County File: OAR-20-019 / OAR-18-016

Re: Aspen Ranch Preliminary Plat

To: City of Fountain – Kristy Martinez (Kristy@fountaincolorado.org)

KANE ROAD PLAN

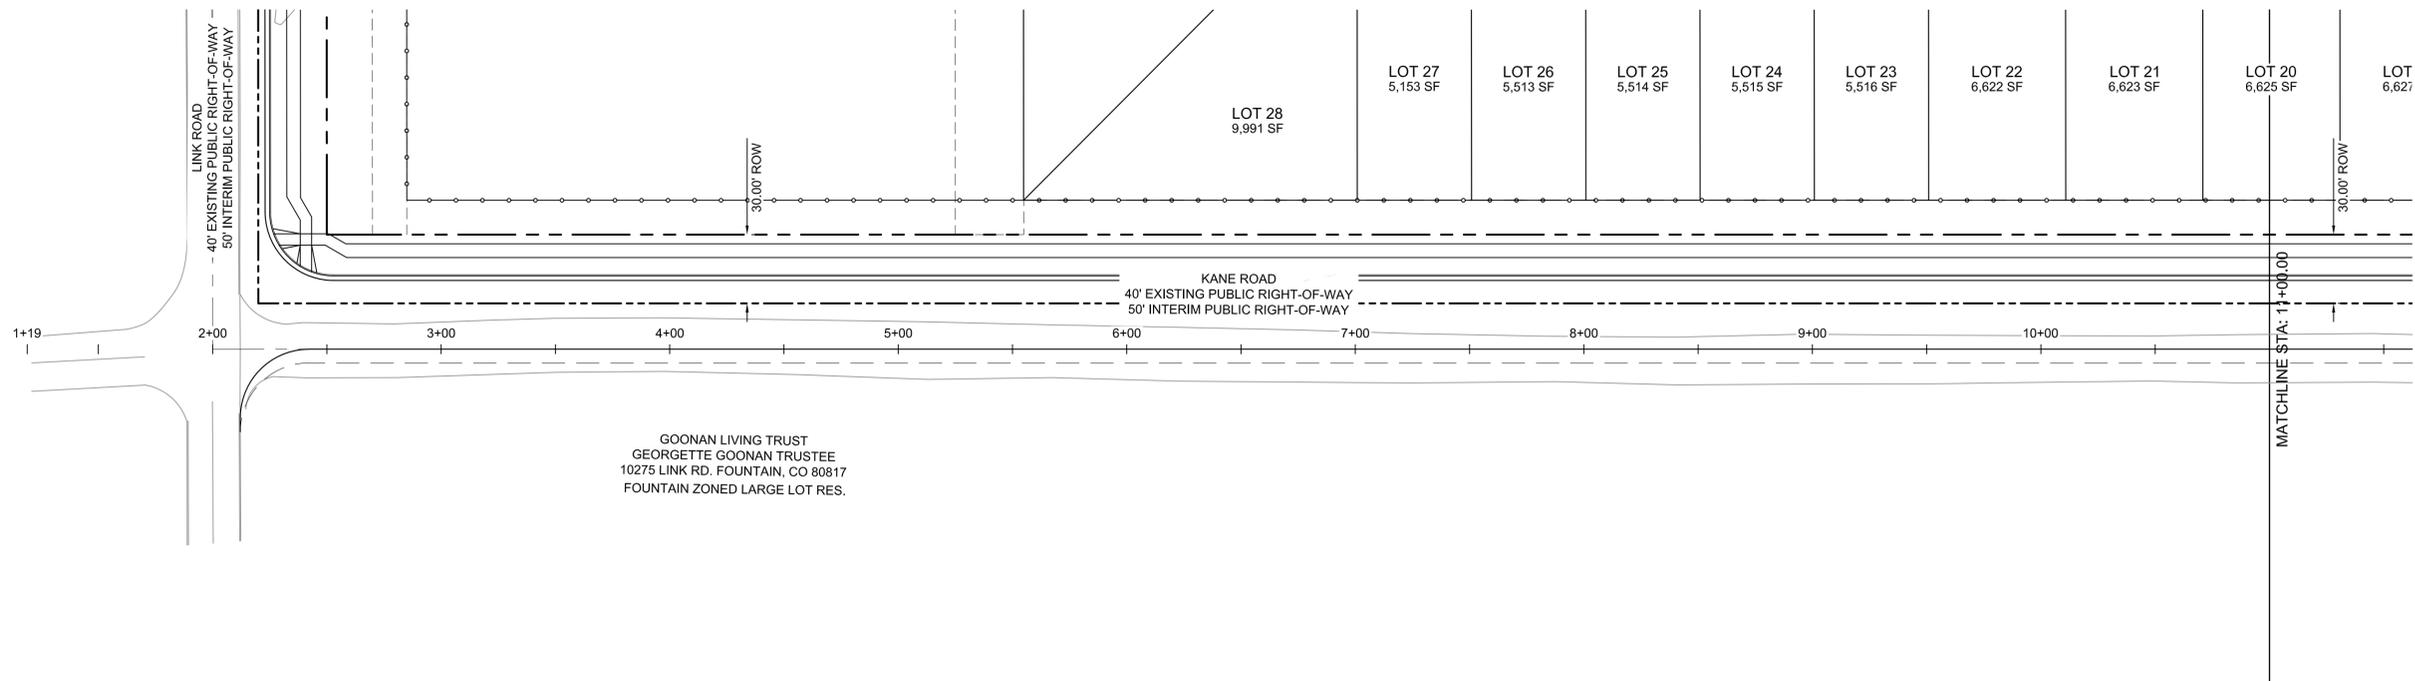
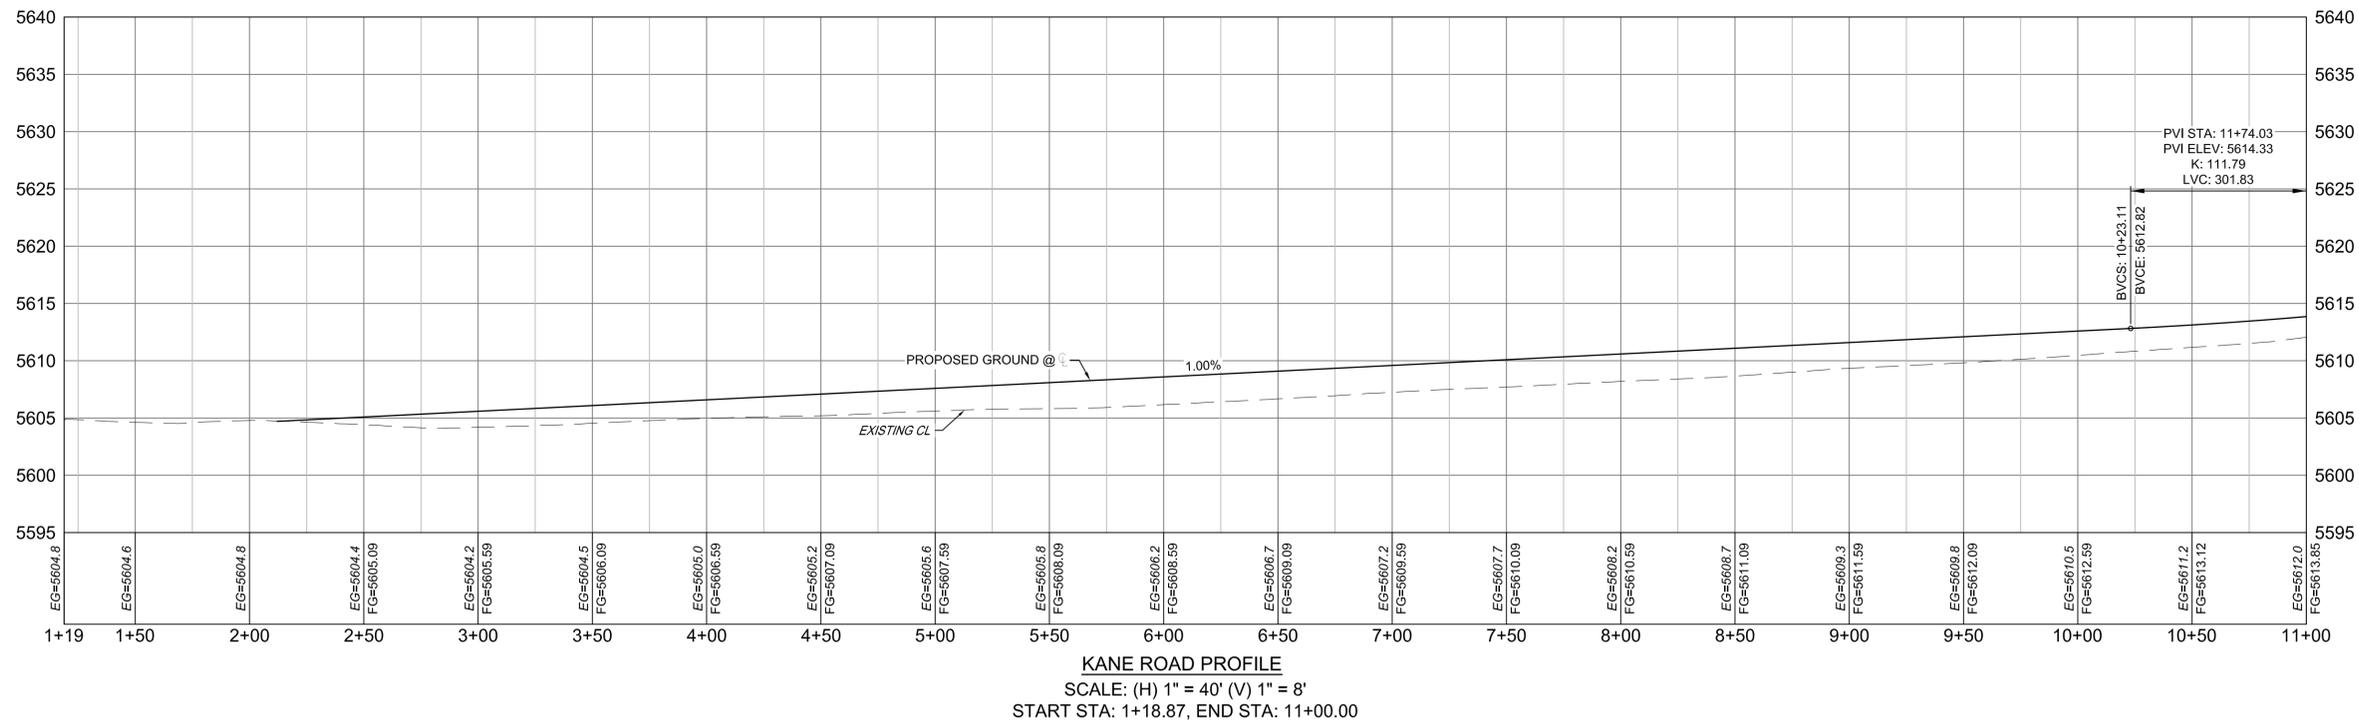
1. Construction plans for any improvements to Kane and R E A Roads under County ownership need to be submitted to the County for review. Alternatively, if the City annexes these roads completely, **which is the County's preference,** construction plans would be submitted to the City. **RESPONSE: NOTED, ALL CITY OF FOUNTAIN AND EPC ARE IN CURRENT DISCUSSIONS REGARDING OWNERSHIP AND MAINTENANCE OF ADJACENT ROADWAYS. ALL DESIGN WILL MEET CITY OF FOUNTAIN STANDARDS. REA ROAD IS NOT AFFECTED WITH THIS PROJECT AND THEREFORE NOT INCLUDED IN THE DESIGN.**
